**Transport
for NSW**

**Mixed Use Redevelopment of 85 Harrington Street and 68-72 Gloucester Street, The Rocks
and Variation to the Sydney Cove Redevelopment Authority Scheme
Notice of Exhibition**

Thank you for your letter dated 15 August 2016, requesting Transport for NSW (TfNSW) review and comment on the above.

**Plans
Basement Level 1**

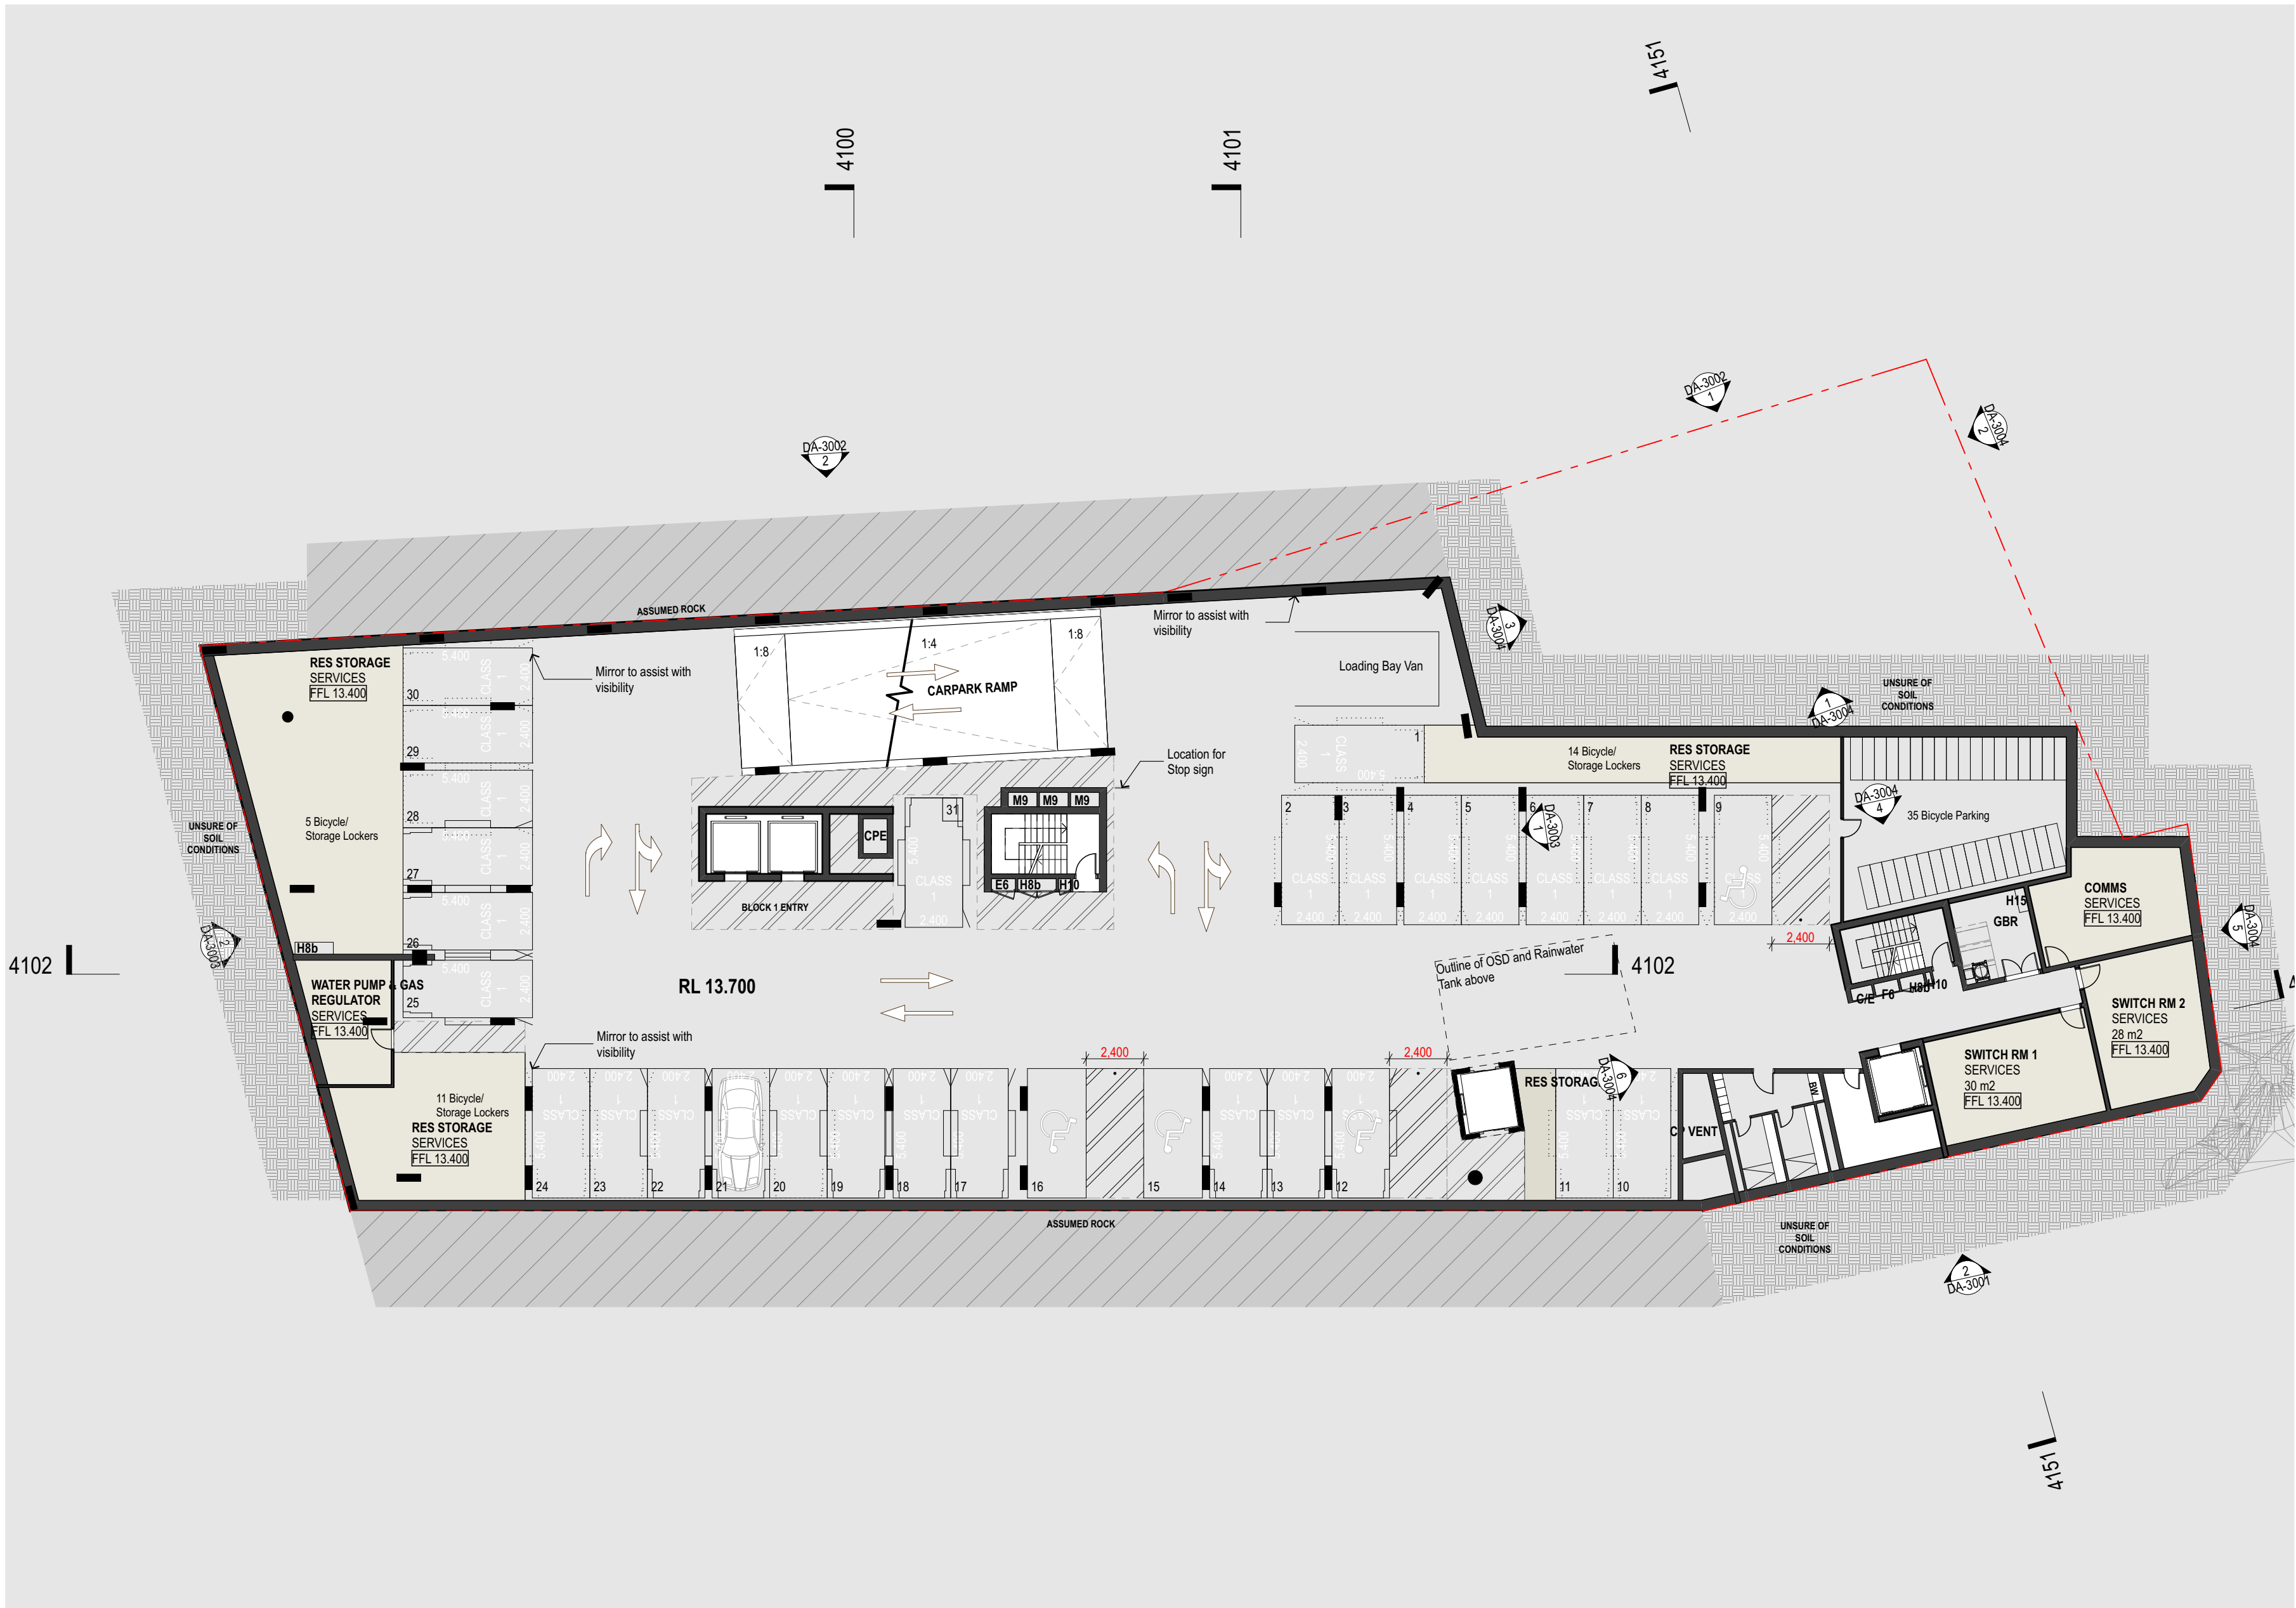
The Traffic Impact Assessment Report prepared to support the development application states that small rigid vehicles are the largest vehicle that can be accommodated in the loading bay and the proposed development would also rely on the use of the on-street loading in the vicinity of site. TfNSW advises that:

- The applicant should not rely on the kerb side restrictions to conduct their business activities;
- All new developments should cater for all loading and servicing to be conducted on-site; and
- Kerb side restrictions are set to suit the wider community needs and are constantly subject to change based on network requirements.
